WEST SUSSEX COUNTY COUNCIL CONSULTATION

TO:	Arun District Council FAO: S Davis
FROM:	Highways, WSCC
DATE:	1 st May 2018
LOCATION:	Formerly Westside Supplies Unit West of, 17-18, Durban Road, Bognor Regis, West Sussex, PO22 9QT
SUBJECT:	BR/90/18/PL Demolition of two storey building & erection of three storey block of 8 No. one bedroom flats & 6 No. two bedroom flats with access from Durban Road (resubmission following BR/87/16/PL).
RECOMMENDATION:	☐ Advice ☐ Objection ☐ Modification ☒ No Objection ☐ More Information ☐ Refusal
S106 CONTRIBUTION TOTAL:	£17,840 See below for breakdown.

Metres
18 Durban Road
Bognor Regis
Block Plan 1:500
A4 Paper

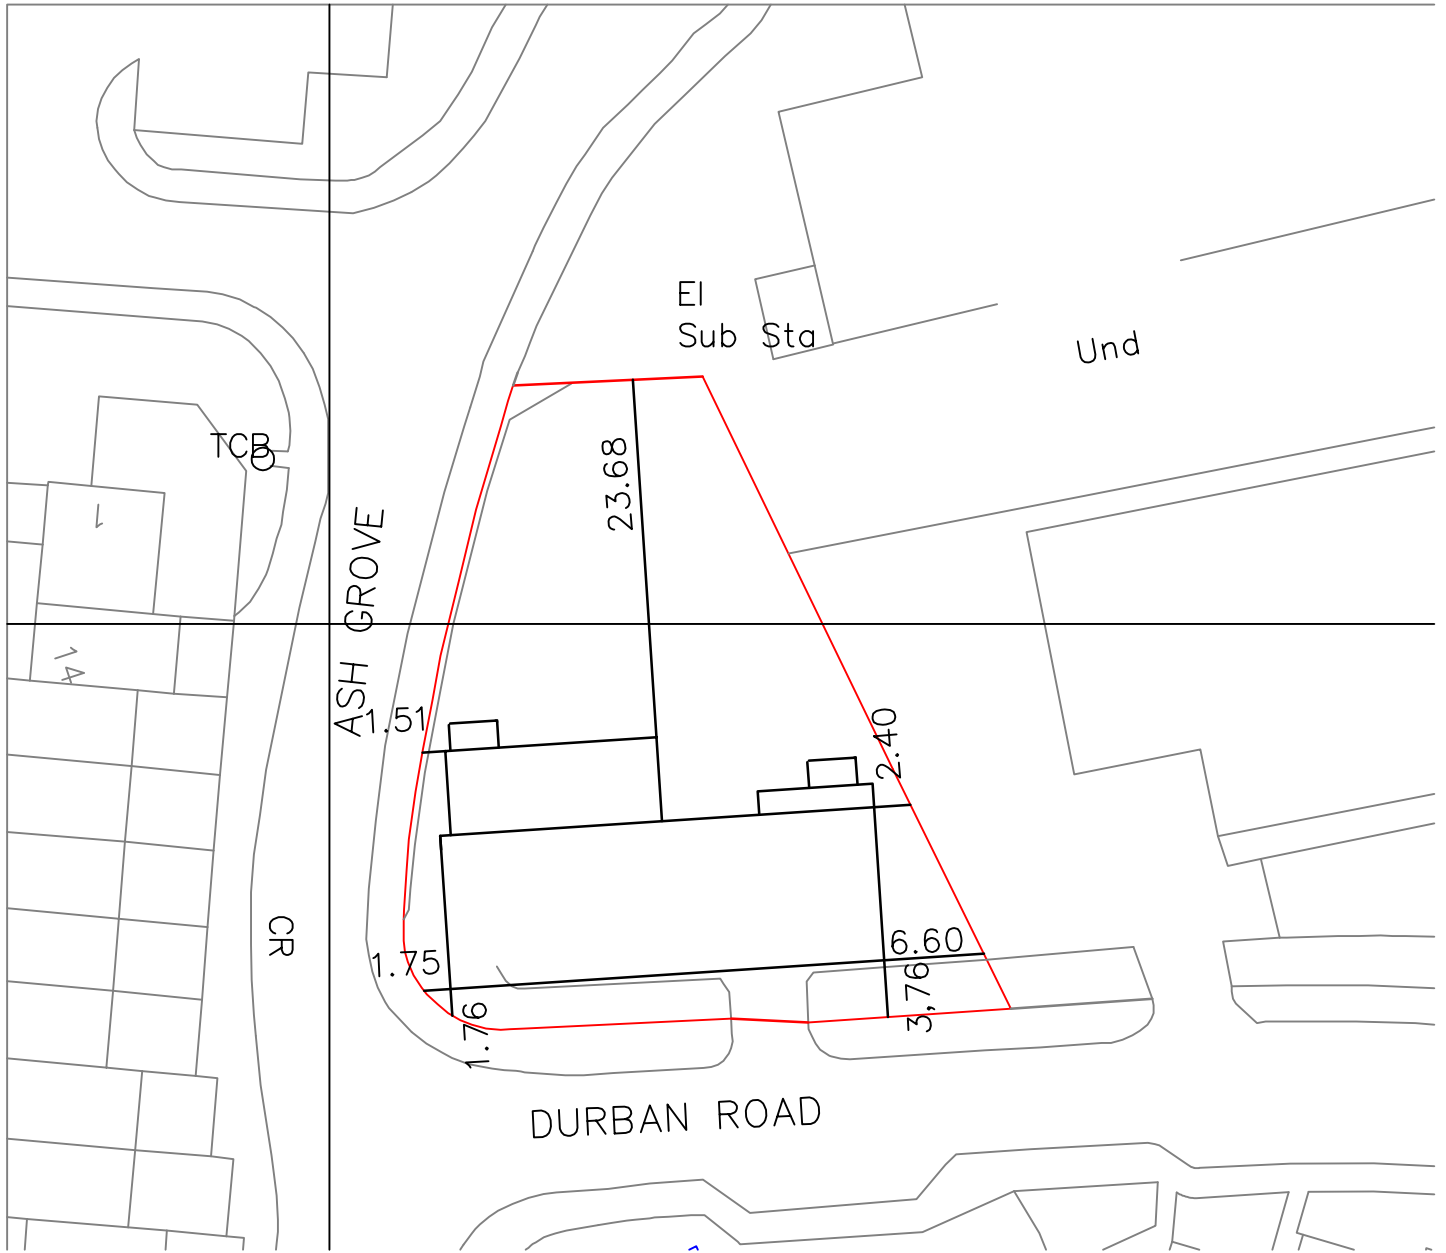
The site is positioned at the junction of Ash Grove and Durban Road, both subject to a 30 mph speed restriction. Vehicular access is from the unclassified Durban Road via an existing vehicular crossover (VCO). From an inspection of local mapping and the plans provided the VCO is of suitable width and geometry for the anticipated vehicle movements and is wide enough to allow two cars to pass.

Visibility to the east is in line with Manual for Streets (MfS) parameters where 43m of stopping sight distance, from 2.4m back into the access, would be applied as suitable for vehicle speeds of 30mph. To the west 25m is achievable to the junction with Ash Grove. Splays are achievable entirely within publically maintained highway.

The plans indicate boundary treatment of 1m height. Considering the adjacent footway there would be a benefit to providing pedestrian visibility splays either side of the access within the site of 2m by 2m. The boundary fencing within these splays should be kept to a height of 0.6m or below in order that emerging vehicles can account for pedestrians on the adjacent footway. Details of this can be secured by condition.

Parking bays meet the required 2.4m by 4.8m to be counted toward parking provision with 6m space rear of these to facilitate a turn on site, as per guidance in MfS. Fifteen spaces will be provided. On the basis that these remain of an unallocated arrangement the WSCC Car Parking Demand Calculator envisions a demand for 12 spaces at the site. The LHA therefore consider that the quantity of parking is suitable for the development's needs.

No part of the development shall be first occupied until such time as the vehicular access with the modifications proposed serving the development has been constructed in accordance with the approved drawing.

No part of the development shall be first occupied until a northern visibility splay of 2.4 metres by 43 metres has been provided at the junction of Durban Road and Ash Grove in accordance with the approved planning drawings. Once provided the splays shall thereafter be maintained and kept free of all obstructions over a height of 0.6 metre above adjoining carriageway level or as otherwise agreed.

No part of the development shall be first occupied until the vehicle parking and turning spaces have been constructed in accordance with the approved plan. These spaces shall thereafter be retained for their designated use.

No part of the development shall be first occupied until pedestrian visibility splays of 2 metres by 2 metres have been provided either side of the site vehicular access onto Durban Road in accordance with plans and details submitted to and approved in writing by the Local Planning Authority. These visibility splays shall thereafter be kept free of all obstructions over a height of 0.6 metre above adjoining carriageway level or as otherwise agreed.
